Phone: 0300 123 6780  
Email: [developeras@lancashire.gov.uk](mailto:developeras@lancashire.gov.uk)  
Your ref: 3/2025/0773  
Our ref: 3/2025/0773/HDC/KW  
Date: 17 October 2025

**Location:** Hambledon View Clerk Hill Road Sabden Lancashire BB7 9DR  
**Proposal:** Proposed extensions and alterations to include two-storey front extension, single-storey rear extension, single storey link side extension adjoining proposed two storey garage with bedroom in roofspace and the construction of a new gated vehicular access and driveway.  
**Grid Ref:** 375581 437008

Proposed Site, Block and Roof Plan

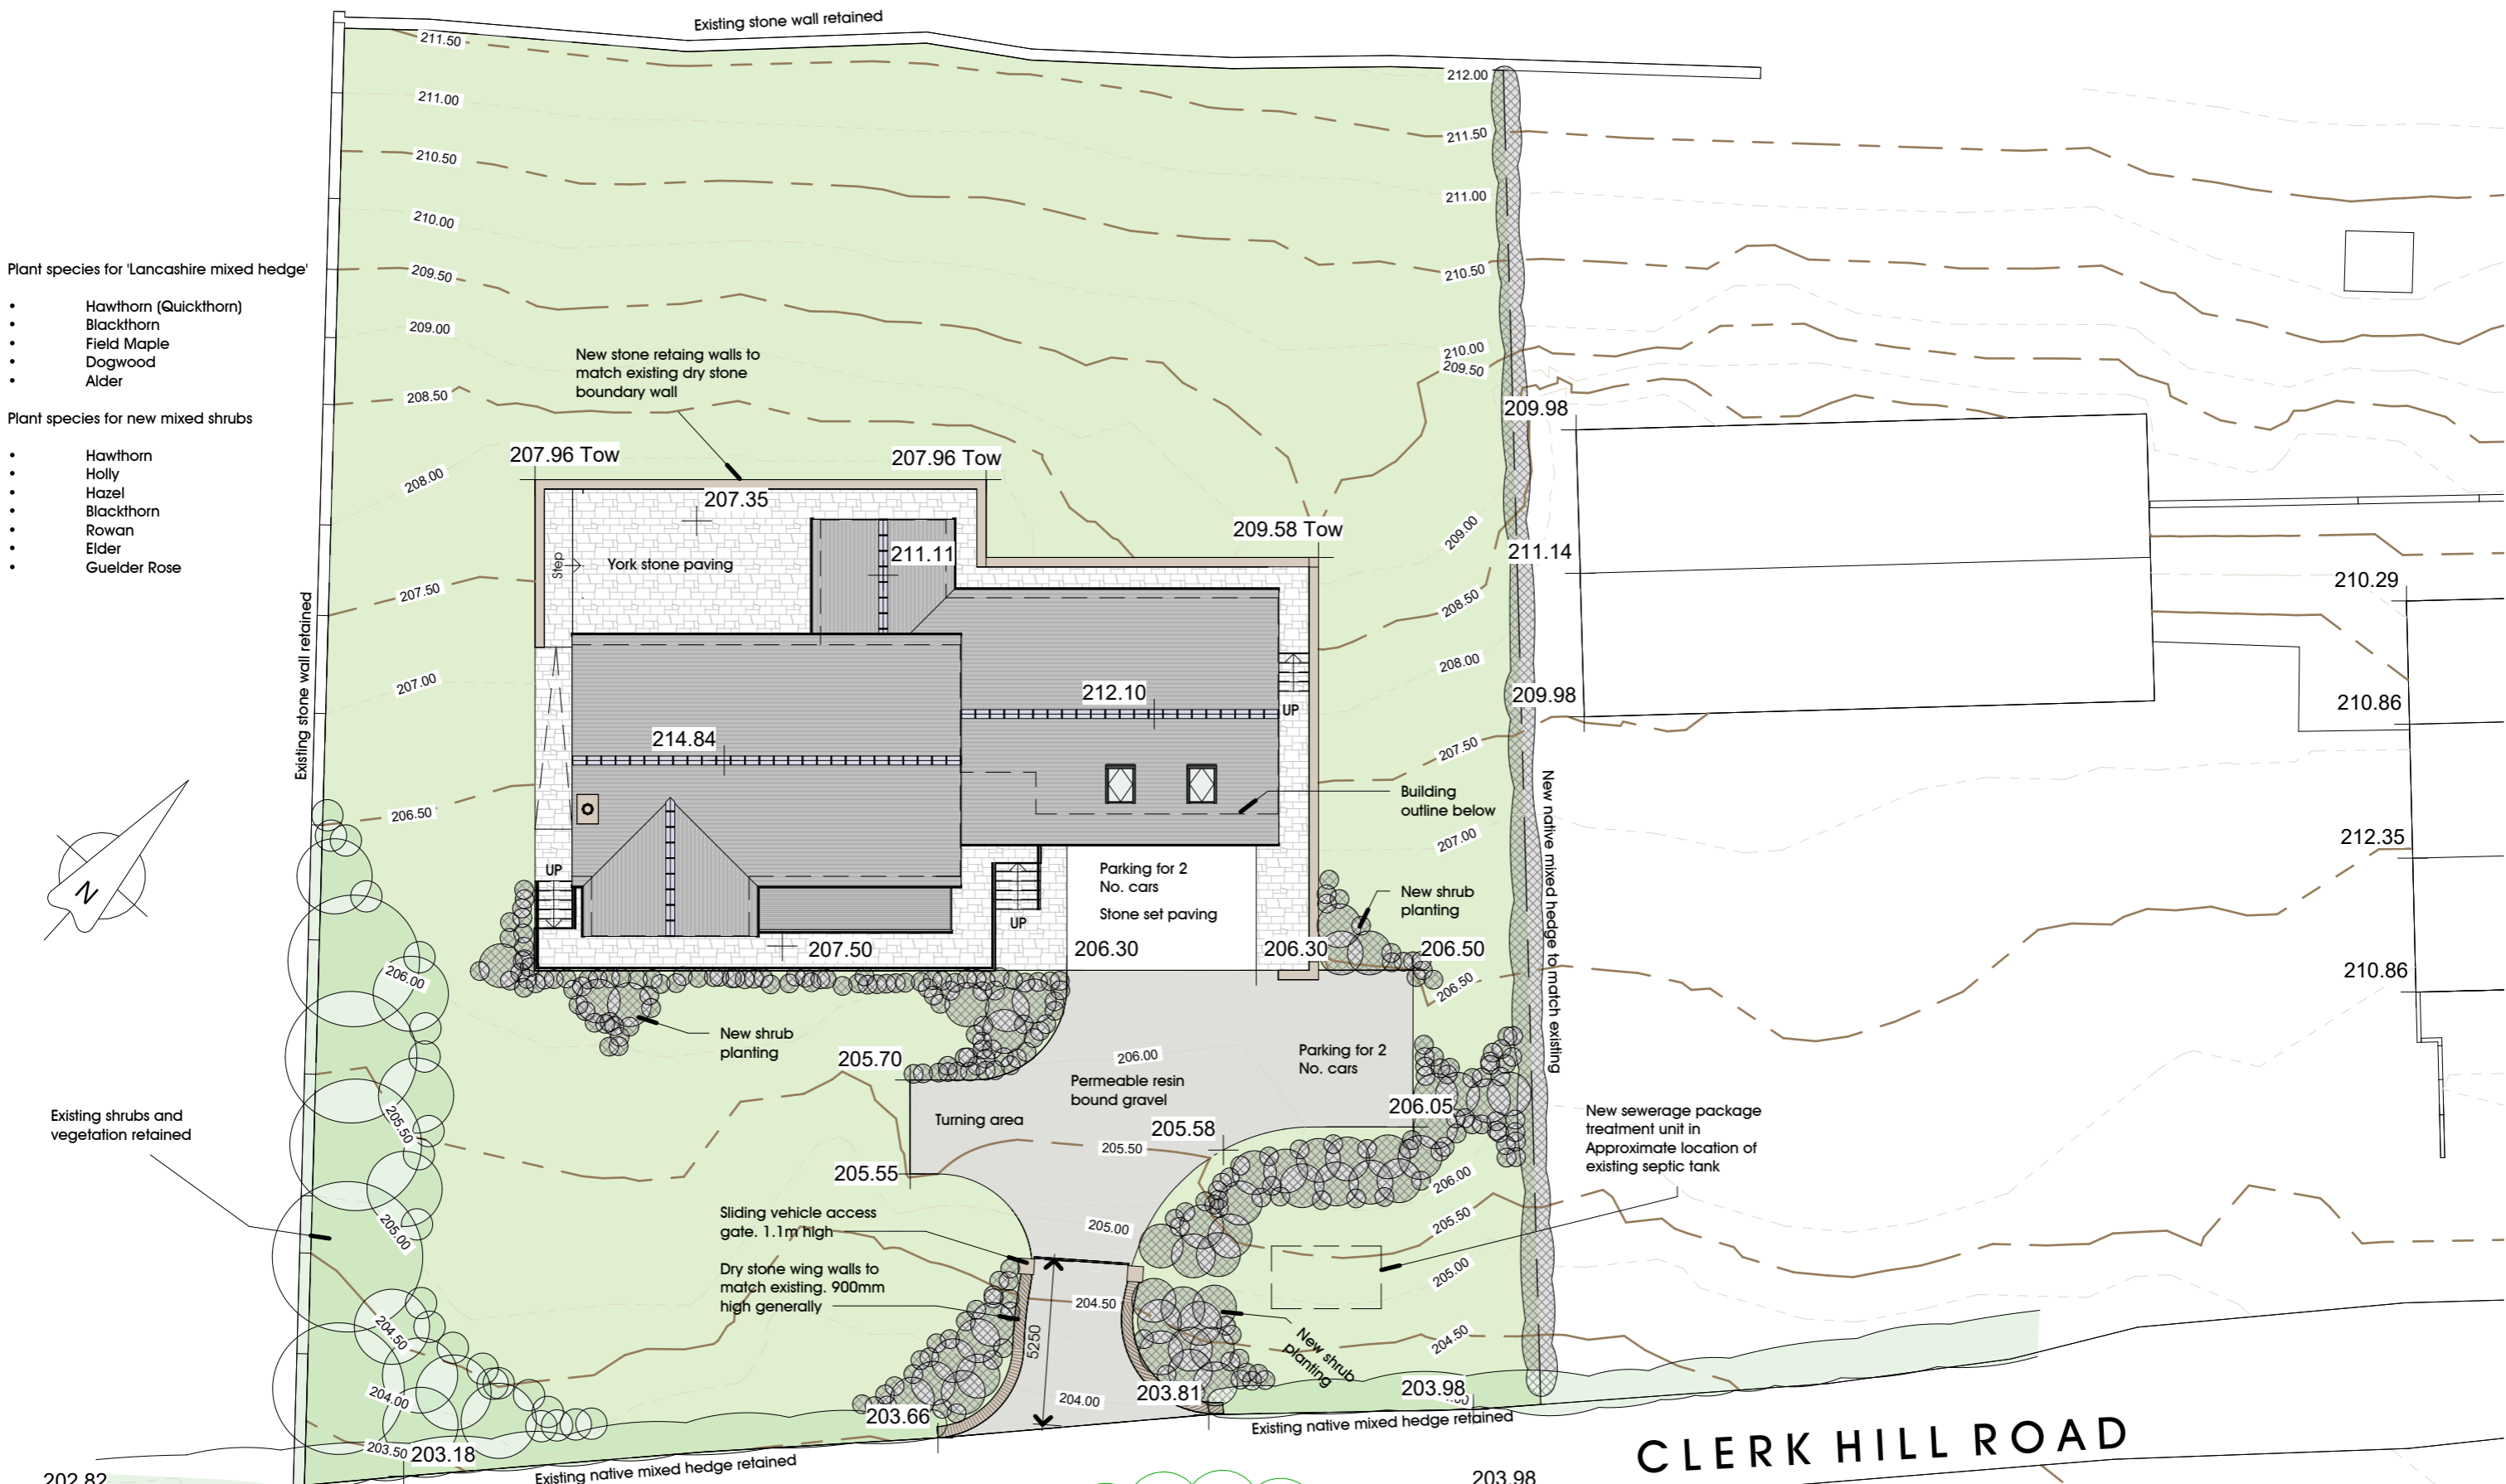
The proposal includes some amendments to the existing access point from Clerk Hill Road which is a private access road with a national speed limit fronting the site access. The proposal includes 0.9m radius walls and a gate placed at least 5m behind the carriageway edge, which is acceptable to the LHA.

A 5-bedroom dwelling should provide at least 3 off-street parking spaces to ensure a negligible impact on highway safety and highway capacity within the immediate vicinity of the site. These spaces should measure at least 5m in length and 2.4m wide, where they

are adjacent to a fence or similar obstruction, an additional width of 0.6m should be provided. If the driveway has shared pedestrian access, an additional 0.8m should also be provided.

The LHA has reviewed the proposed site plan drawing 004 and notes that there are acceptable off-street parking provisions considering the size and nature of the dwelling. There are also acceptable turning provisions that enable vehicles to enter and exit the site in a forward gear.

The recommended minimum internal dimensions for a single garage size is 6m in length and 3m wide. The recommended distance of 6m is based on the length of a large family car (Ford Mondeo Estate 4.58m long), clearance at the rear of the car (200mm), overhang of the garage door (600mm) and room to stand in front of the car and open/close the garage door (600mm). As the proposed garage is smaller than the recommended minimum internal dimension, it cannot be counted as a parking space.

1. The parking and manoeuvring area shall thereafter always remain available for parking of vehicles associated with the dwelling. The parking areas shall be properly consolidated and surfaced in bound porous materials, (not loose stone, gravel or grasscrete) and subsequently maintained in good working order at all times thereafter for the lifetime of the development.  
**Reason:** To ensure satisfactory levels of appropriately constructed off-street parking are achieved within the development and to avoid unnecessary parking on the highway to the detriment of highway safety.

2. Any gateposts erected at the access shall be positioned 5m behind the nearside edge of the highway. The gates shall open away from the highway. All gates and associated mechanisms to be located outside the highway and the gates shall have physical restraints to prevent the gates from opening onto the highway.  
**Reason:** To permit vehicles to pull clear of the carriageway when entering the site and to ensure adequate inter-visibility between highway users when exiting, in the interests of highway safety.
